Department of Planning, Housing and Infrastructure
c/- Kirsty Vogel
Major Projects Planning Portal

Re: Request for Secretary's Environmental Assessment Requirements (SEAR's) Baulkham Hills
Battery Energy Storage System

Figure 2 Site map

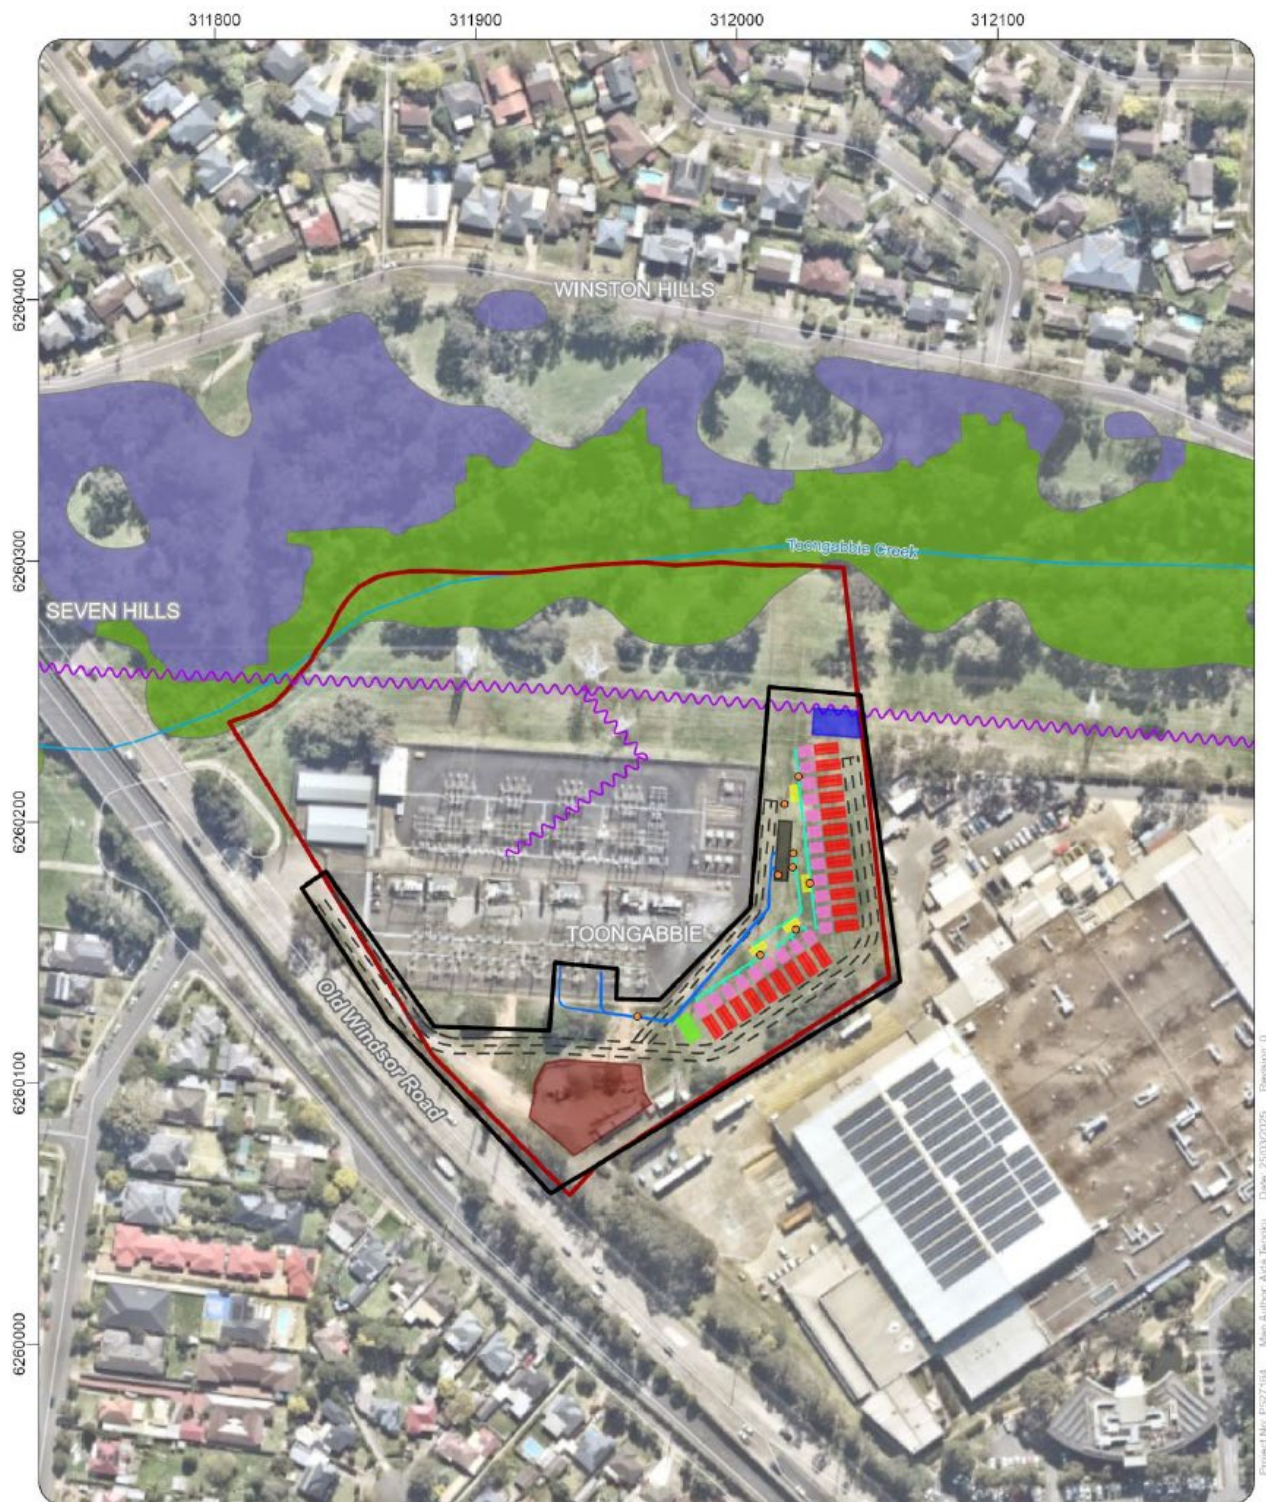
DPIRD Fisheries notes that Toongabbie Creek is mapped Key Fish Habitat and is located approximately 90m north from the project footprint. It is understood from the Scoping Report for the project that stormwater flows and water quality would not be substantially altered by the proposal, and that these would be directed into existing systems. However, it is not clear from the Scoping Report as to whether new stormwater discharges would be into Toongabbie Creek or elsewhere. The department recommends that the project is designed to:

- Avoid works in or adjacent to Toongabbie Creek,
- Minimise potential erosion and sedimentation impacts to the creek during and following construction,
- Maintain or expand the current vegetated riparian buffer zone to the creek and

- Ensure that surface water and groundwater volumes (including stormwater) into Toongabbie Creek are equal to or less than current volumes, or appropriately drip managed, and that water quality in these flows is equal to or improved from current levels.
